**Consultation Response from Biodiversity Officer  
 KC Ecology**
**2019/92587 Wheelwright Centre, Birkdale Road, Dewsbury, WF13 4HG**
**Alterations and partial demolition to convert existing building to form 65 residential units, installation of mezzanine floors, associated landscaping works (soft & hard landscaping) and car parking layout (within a Conservation Area)**
**Date Responded:  
 19/09/2019**
**Responding Officer:  
 Tom Stephenson**
**Responding Ref:**

## Figure 3 – Lighting Strategy

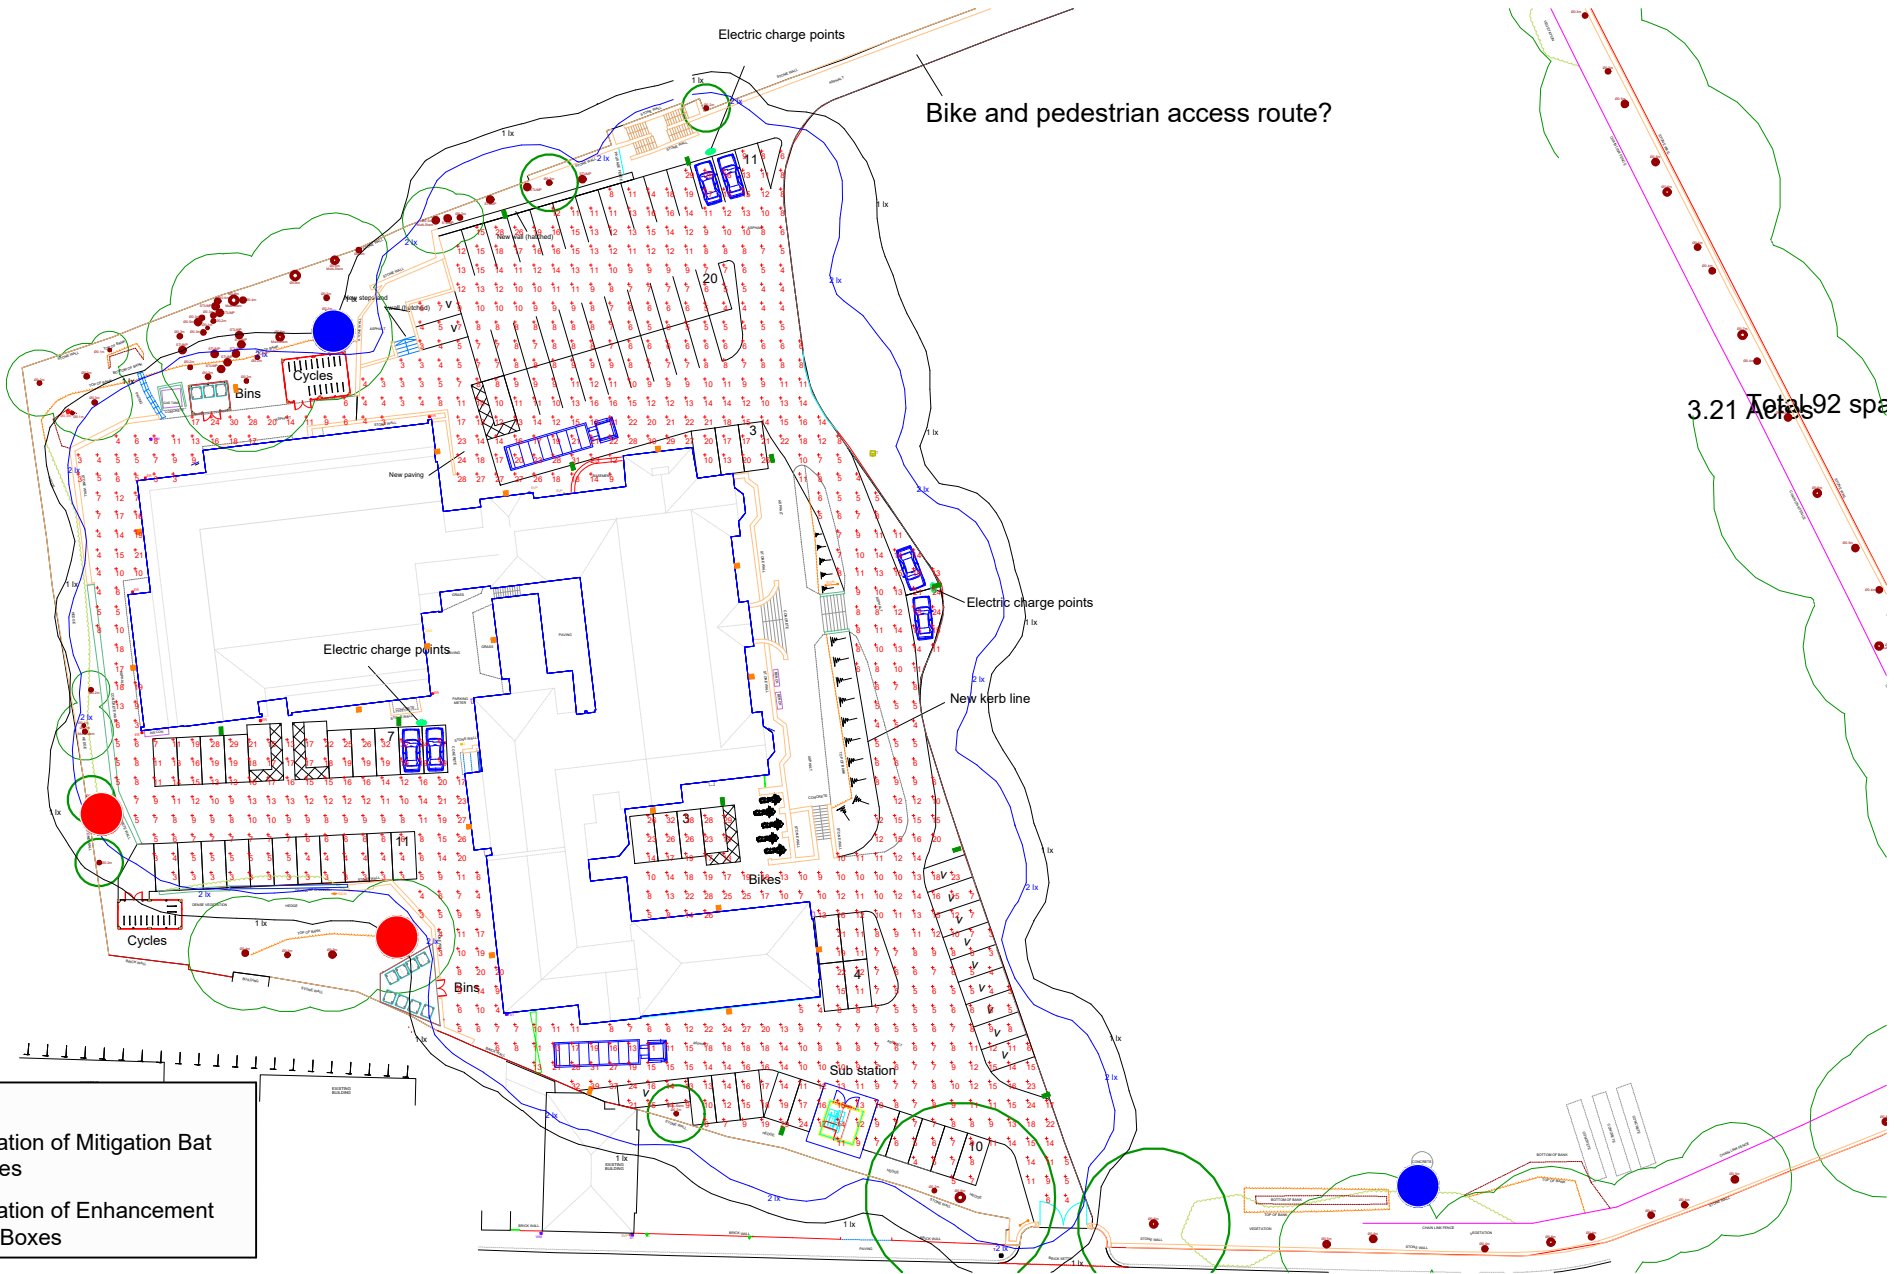
There is no information to demonstrate that the recommendations of the report have been incorporated into the design of the scheme, in particular the lighting design is not in line with these recommendations.

I would suggest that the applicant submits a Mitigation Plan showing how the recommendations of the report have been incorporated in to the design. Following this, it will be possible to condition that works are undertaken in accordance with this plan and under an appropriate mitigation licence.
